CITY OF ALBUQUERQUE

February 14, 2023

Re: SW Corner of Sage & Unser TIS draft, COA comments
Traffic Impact Study, HT#M10D023
Report dated January 4, 2023
Engineer's Stamp 1/4/2023
Via email tbrown@tierrawestllc.com

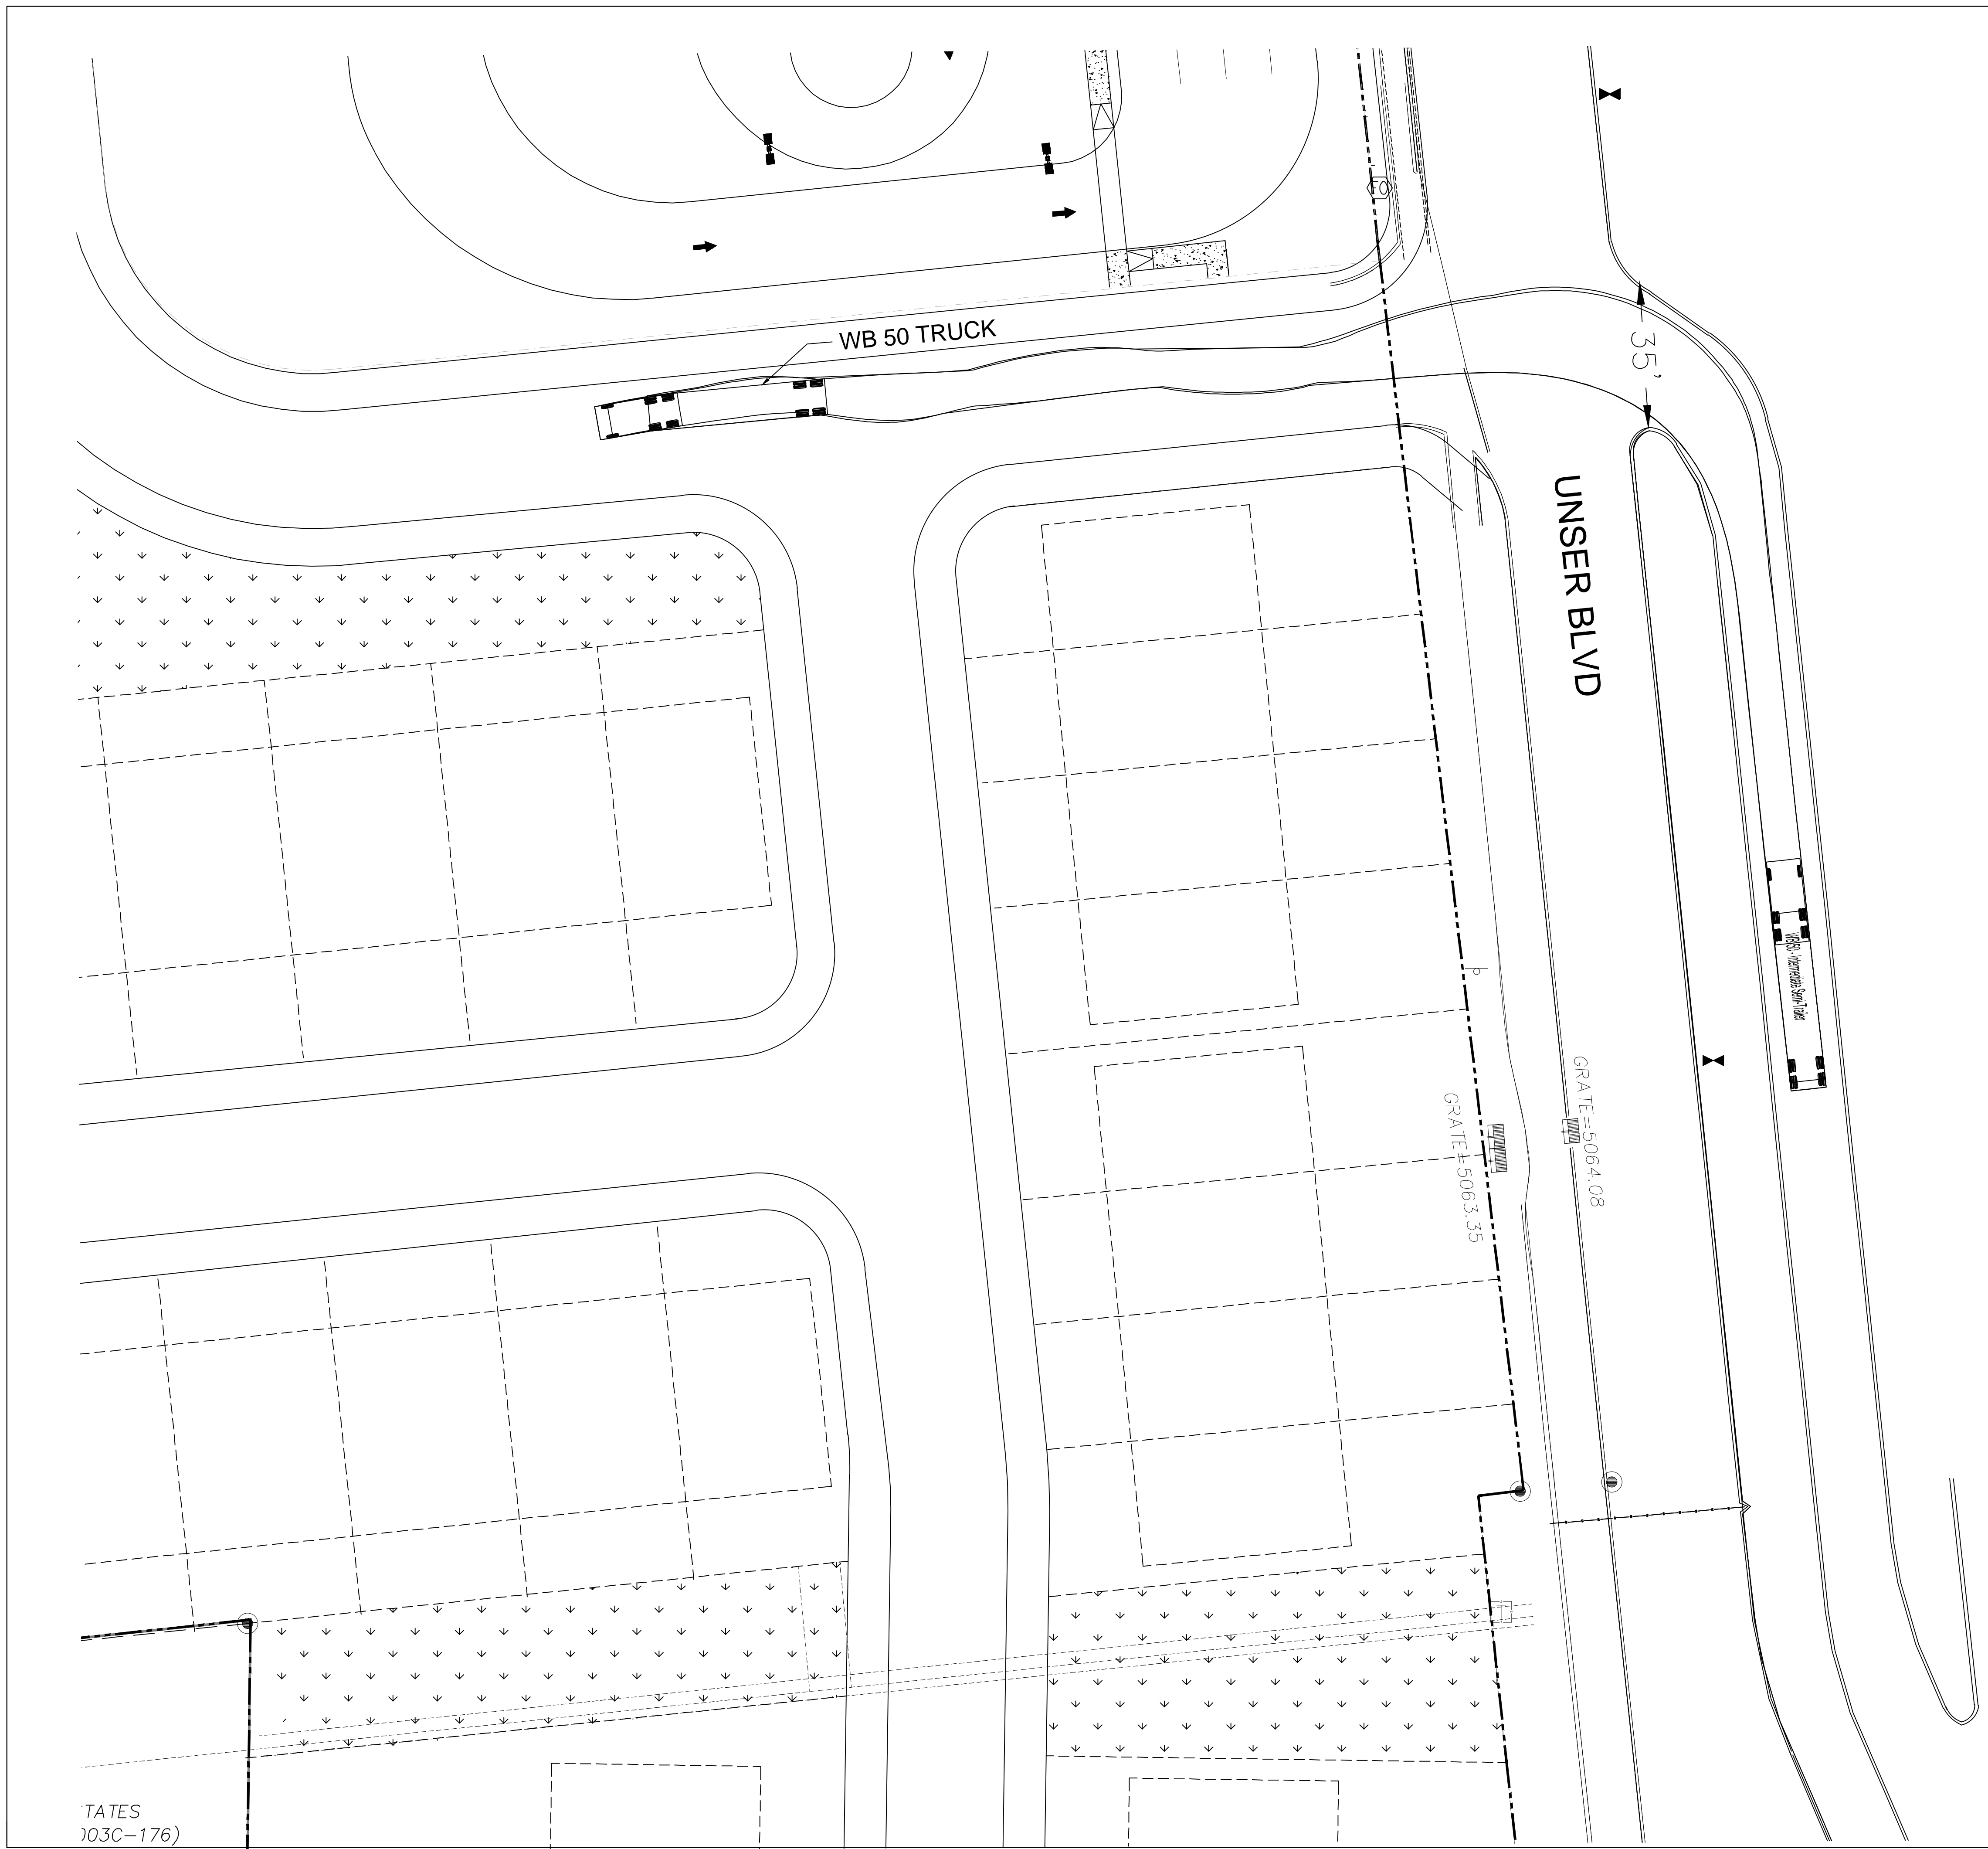
- Is the existing northbound channelized left-turn lane at Driveway "C" wide enough, the correct sized radii for the expected vehicles and aligned with the driveway? Are heavy vehicles anticipated to use this turn lane? Will they fit? Provide a turning vehicle template exhibit for the largest expected vehicle.
